**Atef A. Hanna, P.E**  
**Beacon Civil Engineering**  
**8345 Gunn Hwy**  
**Tampa, Florida 33626**

# CITY OF ALBUQUERQUE

Planning Department  
Alan Varela, Director

C-8.2

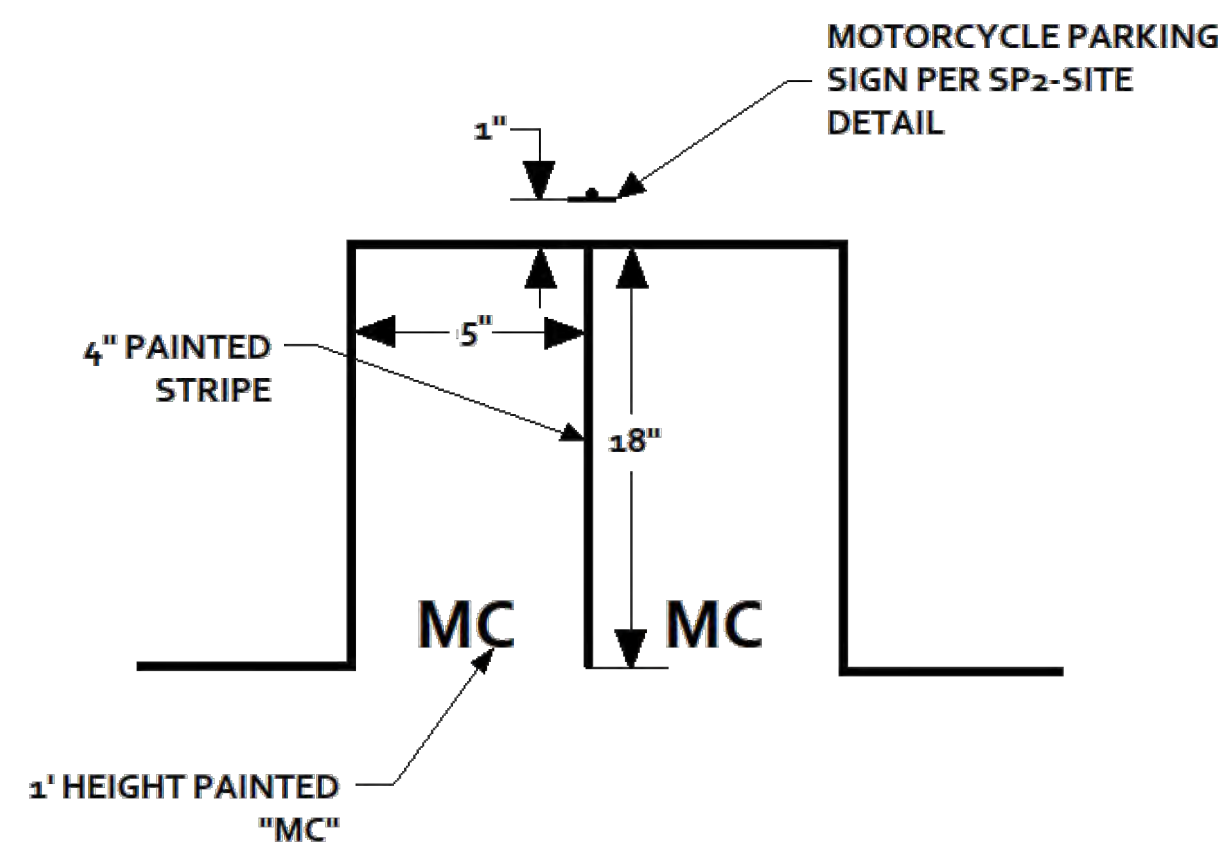
## 2. Anchor down Bike Rack.

FIGURE 7.4.115 Bicycle Parking Stall Layout Options

C-8.0

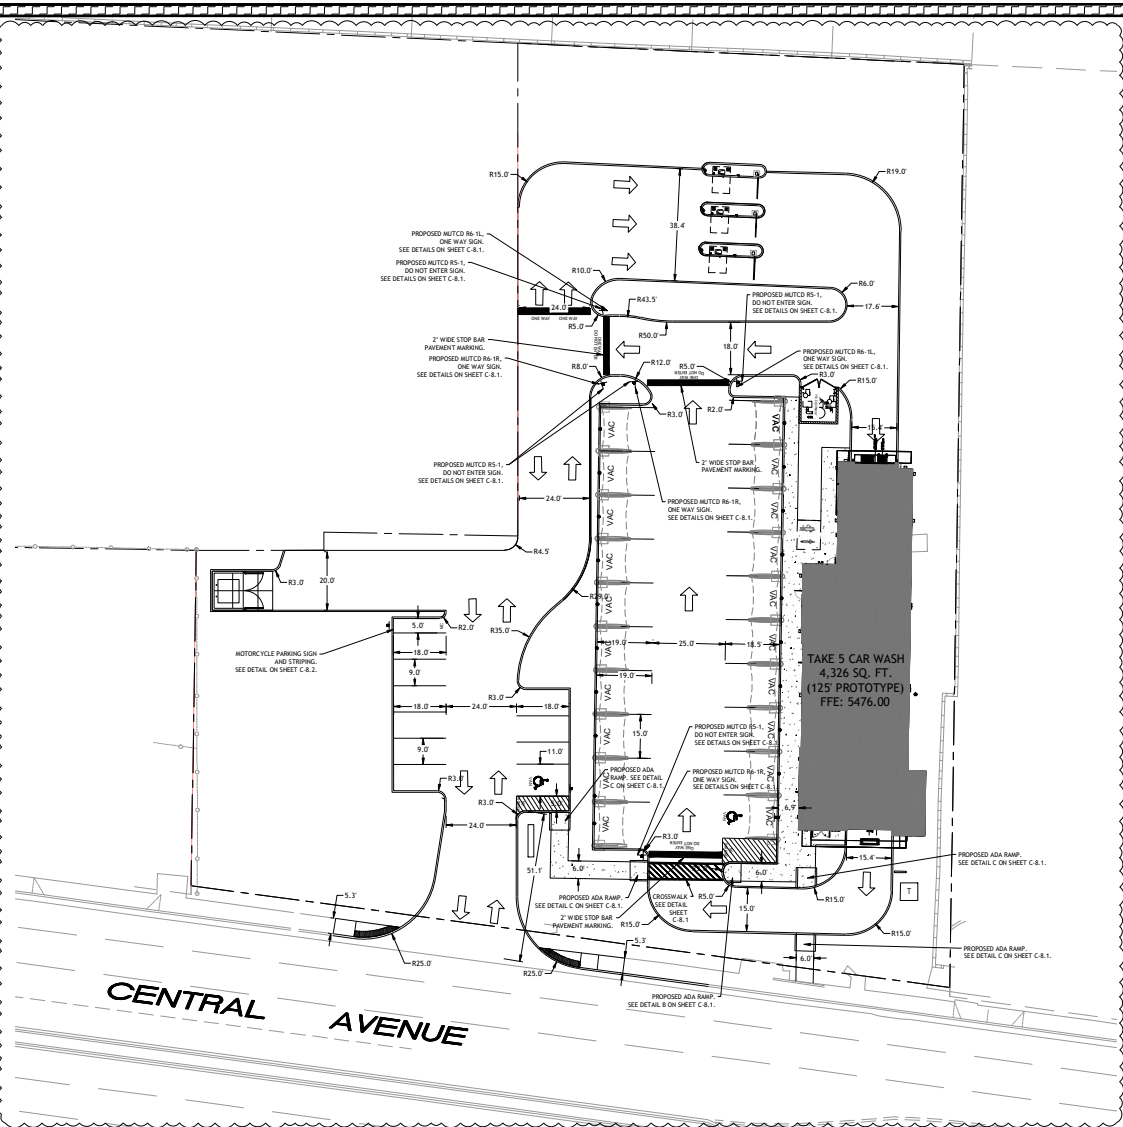
Please relocate the ADA parking space to it's originally approved location as it is adjacent to an ADA pathway to insure safety and efficiency.
